**Kellyville and Bella Vista Station Precincts
(SSD 10343 and SSD 10344)**

The Department requires that you provide a response to the issues raised in those submissions, in accordance with clause 85A(2) of the Environmental Planning and Assessment Regulation 2000. The Department has also identified issues that need to be addressed as a part of your response in **Attachment A**. Please provide a Response to Submissions by 31 January 2020.

Attachment A

Figure 3: Location of Proposed Setback Controls

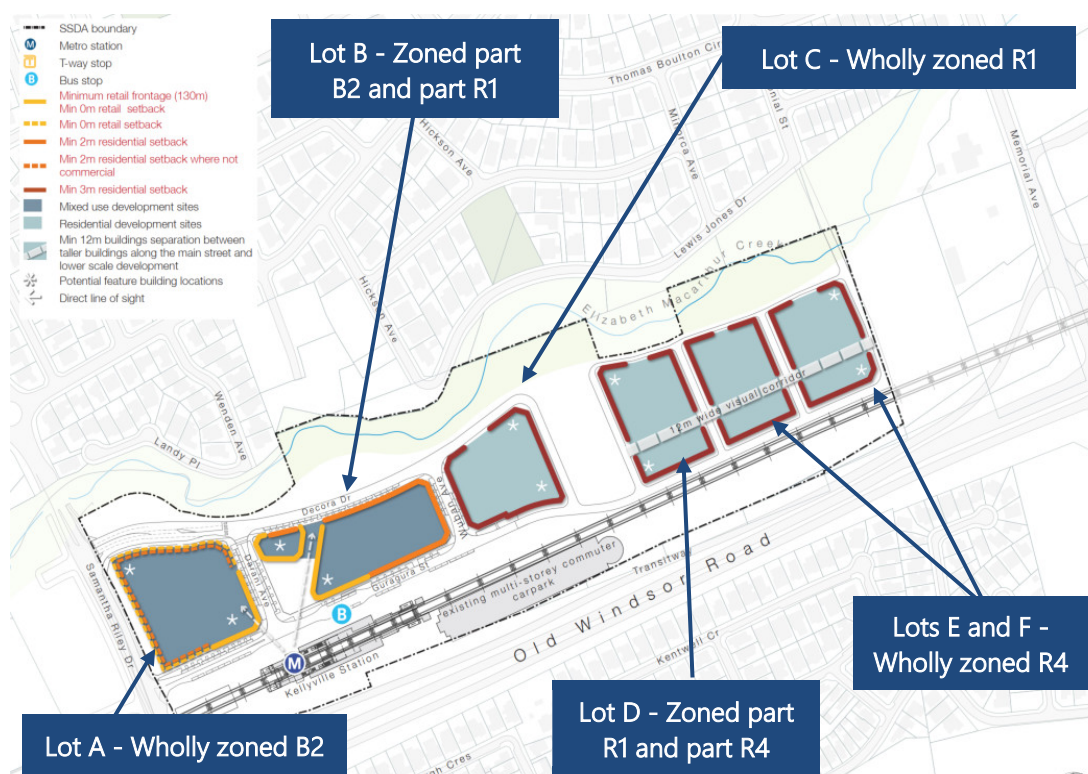
- (iv) Provide further justification/assessment for the proposed clause 4.6 variation to the building setbacks in relation to built form outcomes including delineation of the public/private interface, residential amenity, improved solar access to the public domain, and provision of street planting and services.
